January 16, 2018

**RE: Titan Presbyterian Hotel Block – Sector Plan Map Amendment and Site Plan for Building Permit
Project #1011099, 16EPC-40085/40087**

Conditions of Approval – 16EPC-40087– Sector Plan Map Amendment

Conditions of Approval – 16EPC-40085– Site Plan for Building Permit

LANDSCAPE PLAN FOR  
 BUILDING PERMIT  
 IMM012  
 PROJECT NUMBER SHEET NUMBER

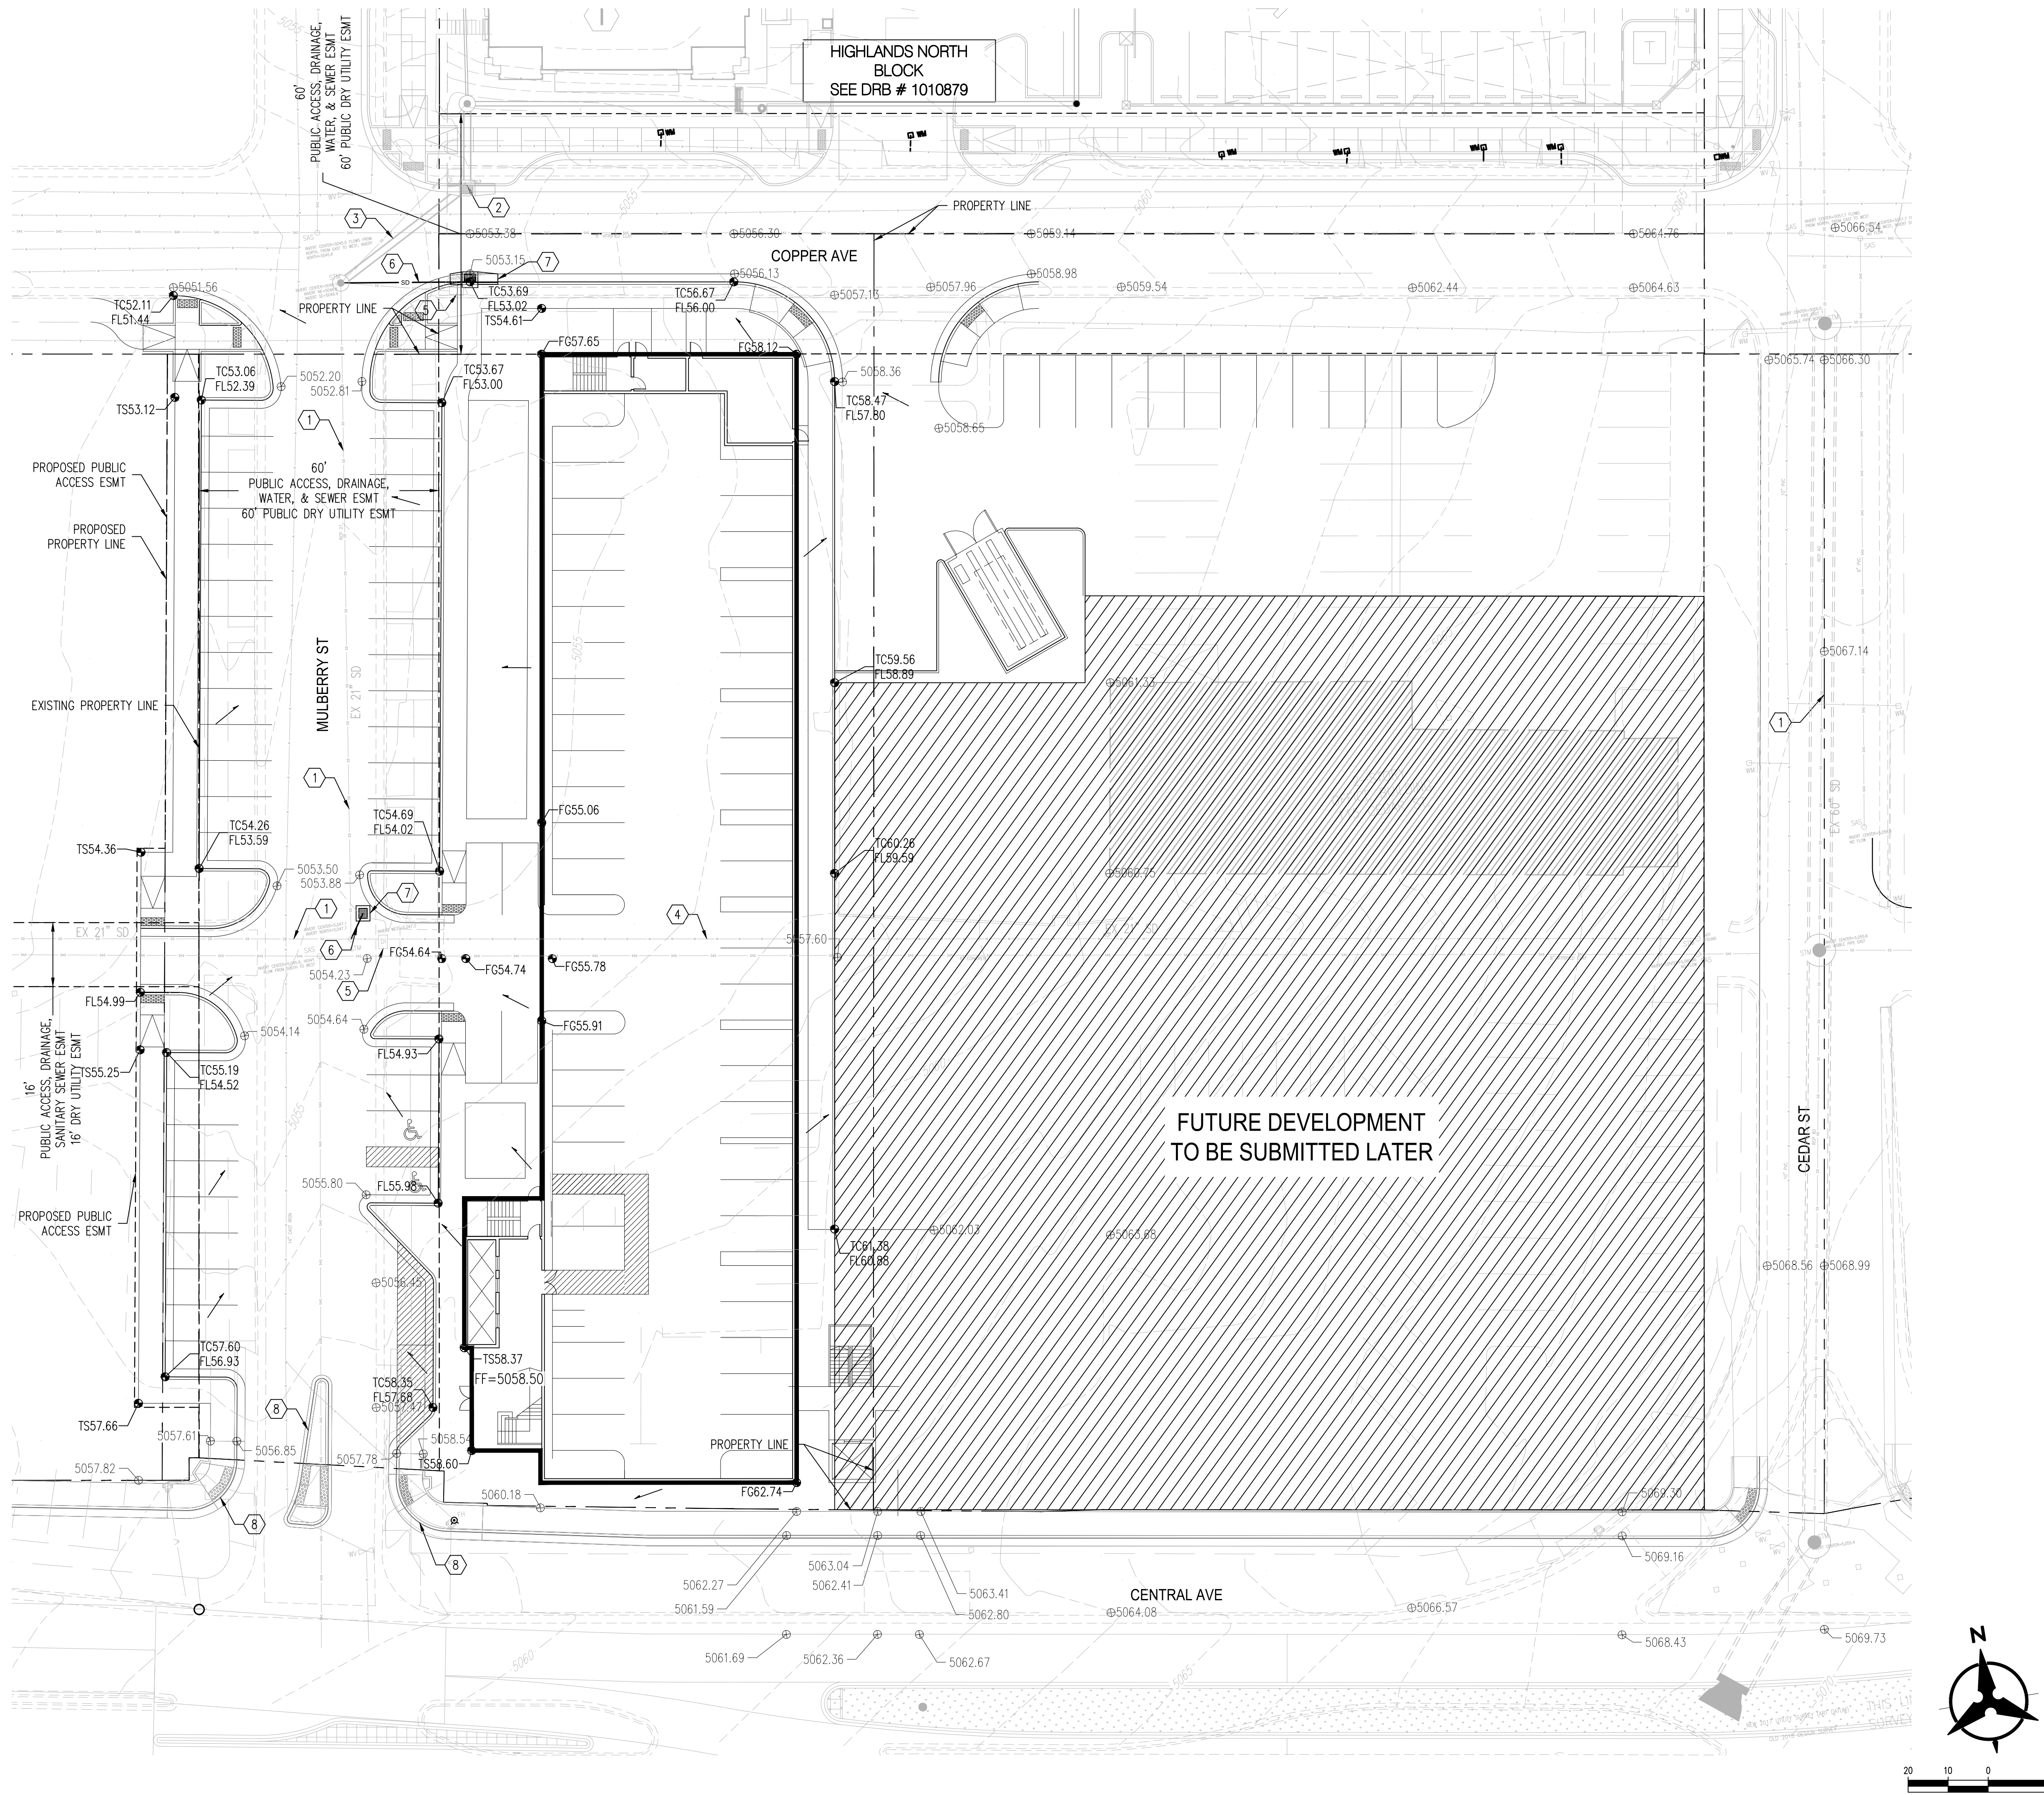
6. On the landscape plan notes, it should be noted that the plans must also comply with Zoning Code Section 14-16-3-22(C)(10) in addition to 14-16-3-10 because the Form Based Zones include specific exceptions to the basic landscaping regulations.

The landscape plan notes have been updated to meet this condition.
